Application no: **3/2019/0854**

Address: **61 Ramsgreave Road Ramsgreave BB1 9BH**

Proposal: **Construction of single storey extension to rear. Conversion of existing attached garage to habitable room and addition of pitched roof**

Lancashire County Council acting as the Local Highway Authority does not raise an objection regarding the proposed development and are of the opinion that the proposed development will not have a significant impact on highway safety, capacity or amenity in the immediate vicinity of the site subject to the following condition being stated on any approval.

PROPOSED PARKING TWO CARS

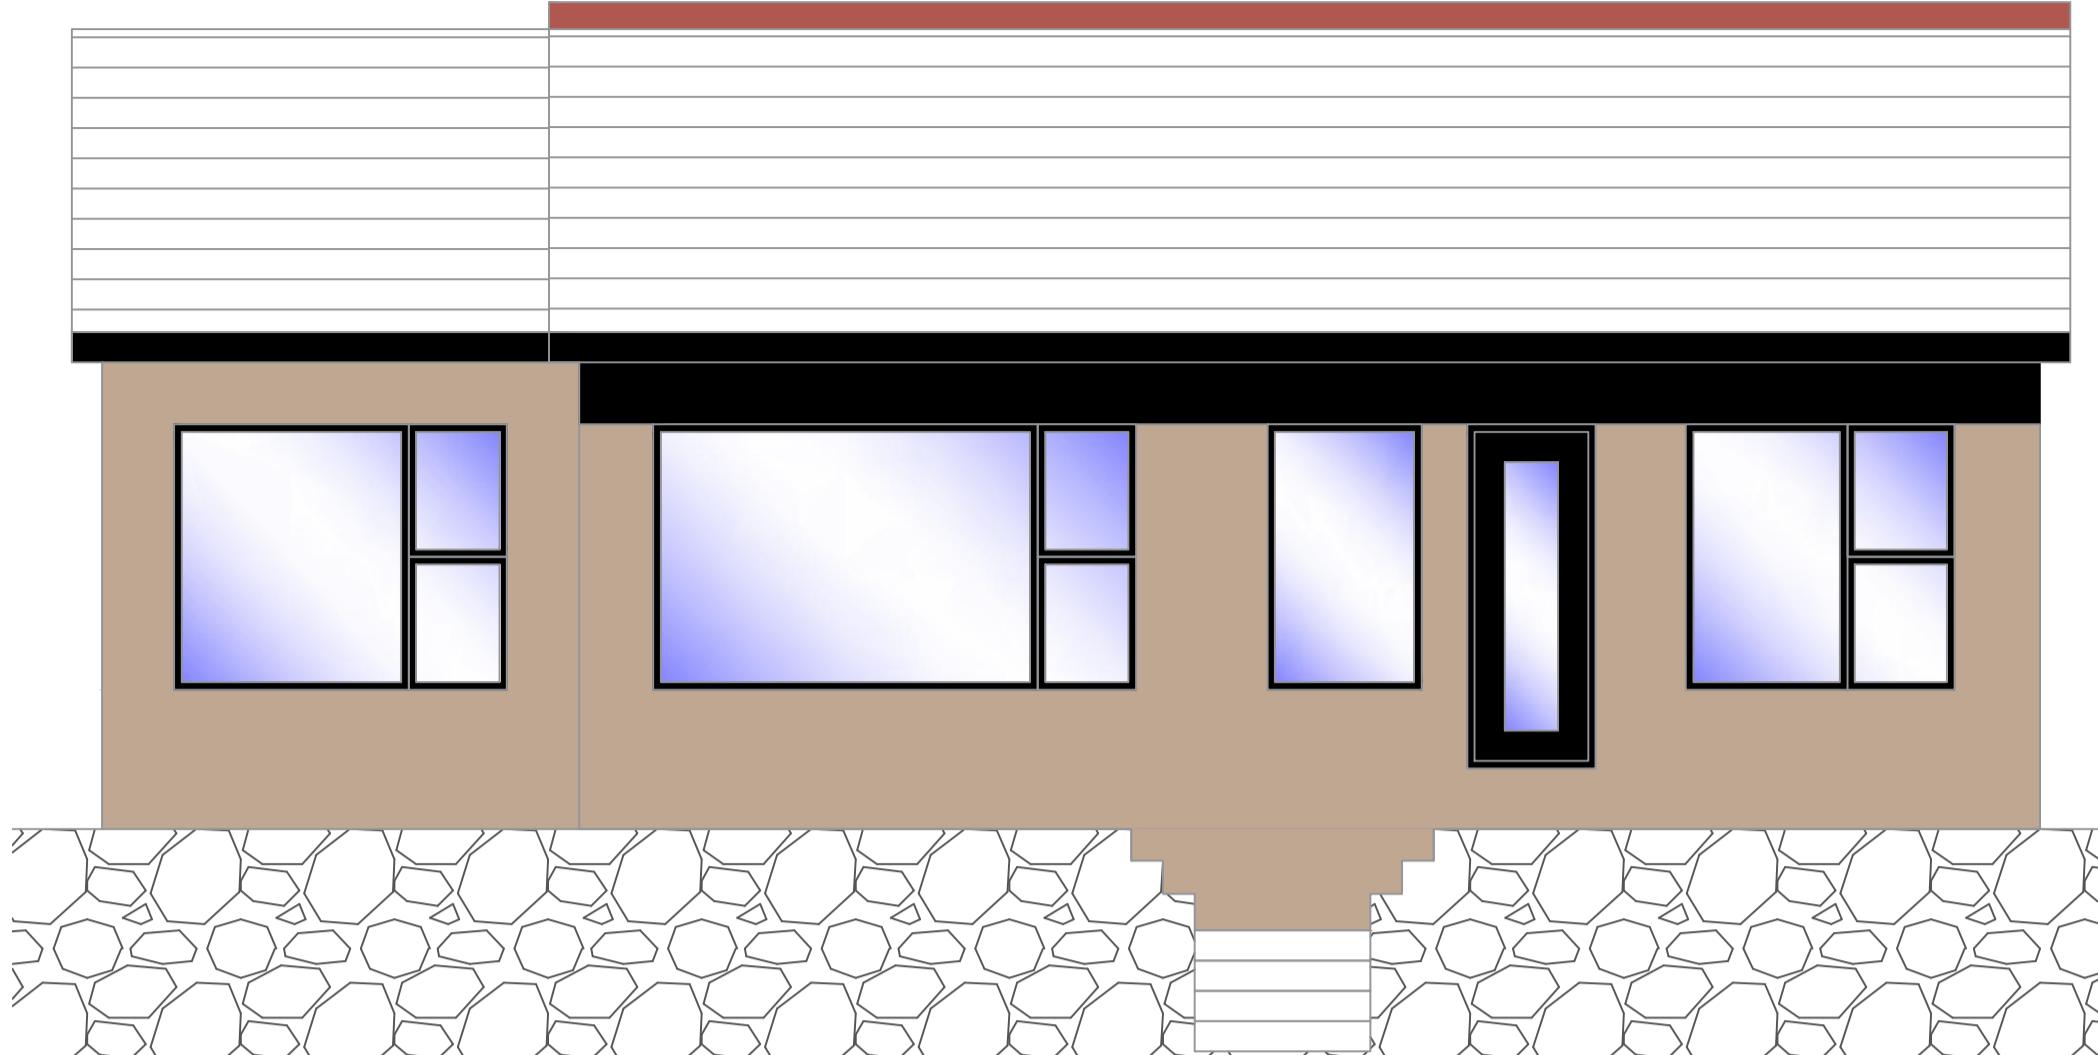
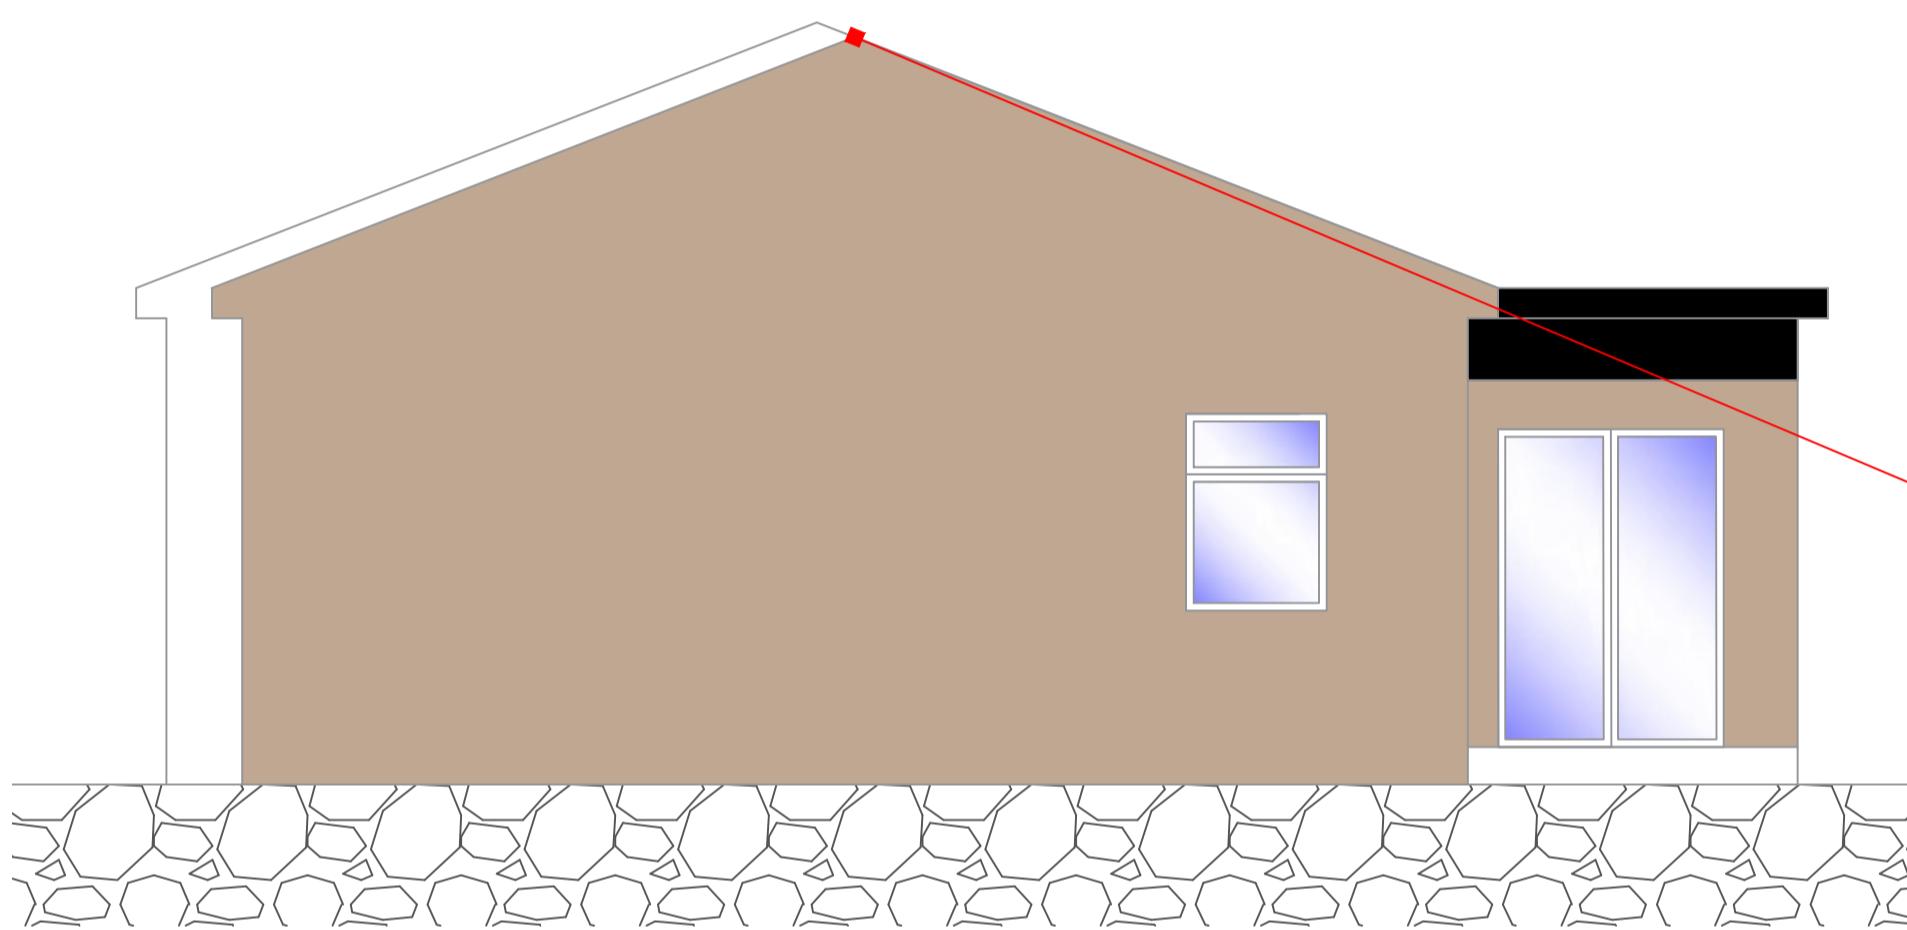
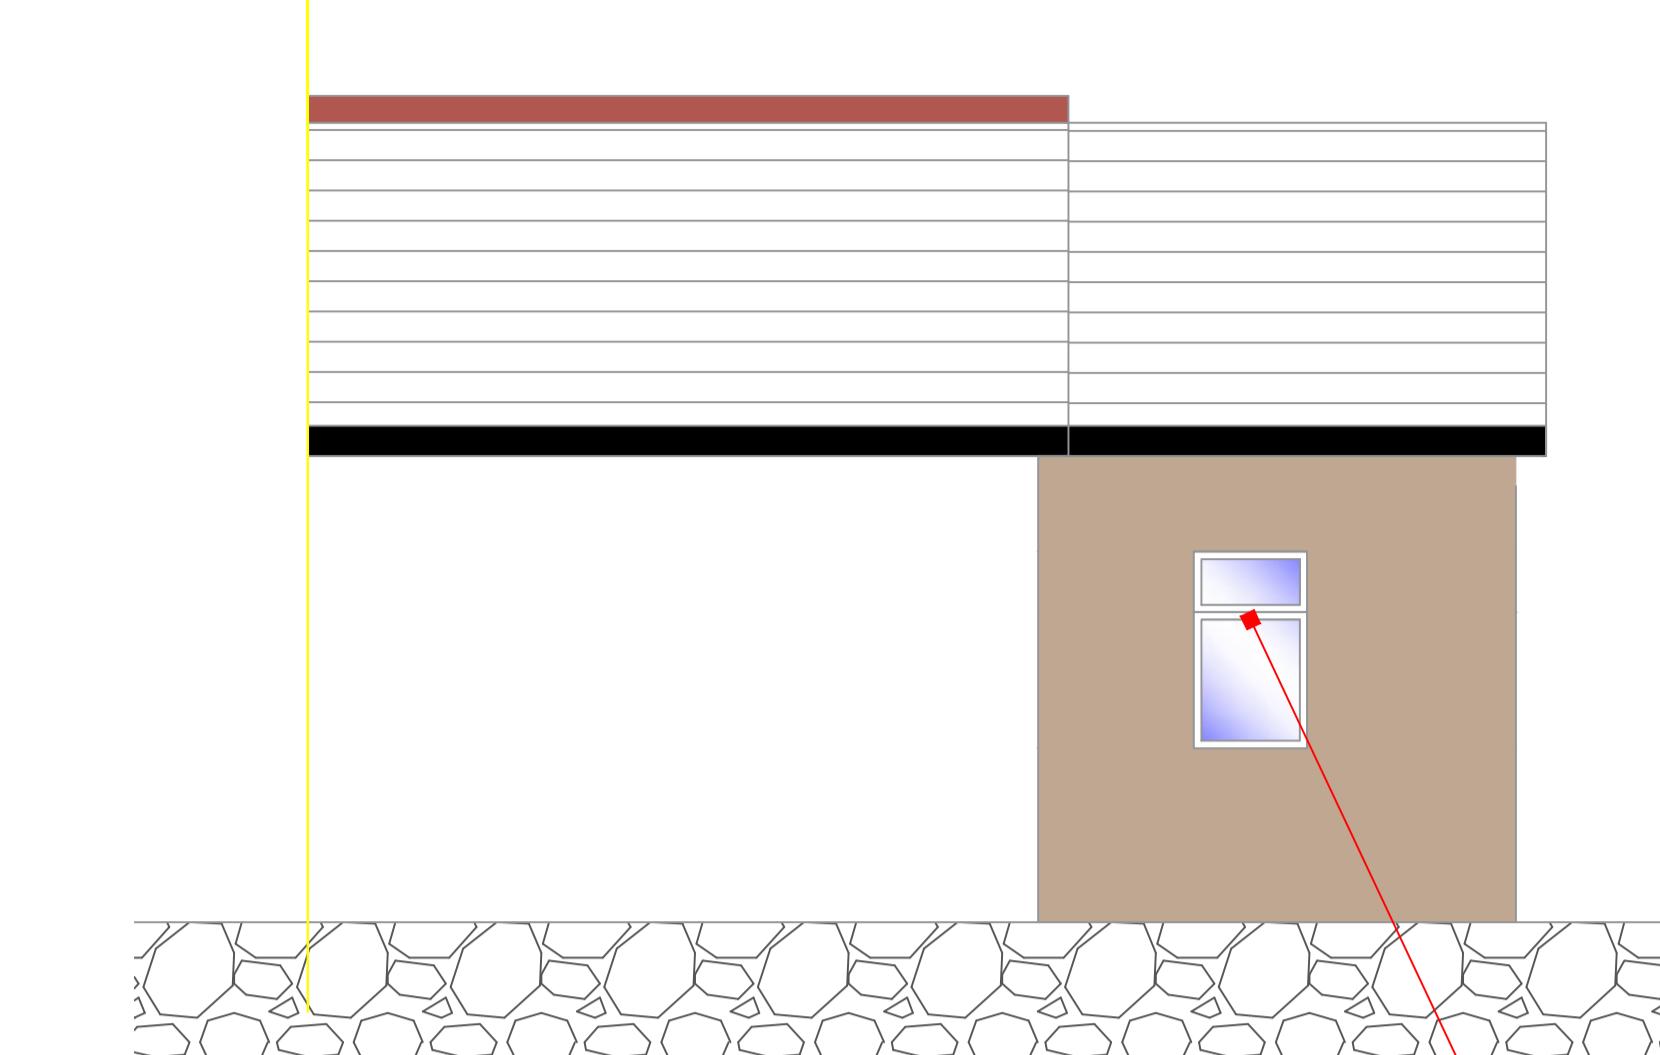
Having received a revised parking layout for the proposal, it would appear the amended parking arrangements would be considered satisfactory to suit the required parking provision. However, the Local Highway Authority will require the driveway to be constructed from an approved bound surface material

1. Before the driveway is used for vehicular purposes, then the driveway extending from the highway boundary for a minimum distance of 5m into the site shall be appropriately paved in tarmacadam, concrete, block paviours, or other approved materials. **Reason:** To prevent loose surface material from being carried on to the public highway thus causing a potential source of danger to other road users.
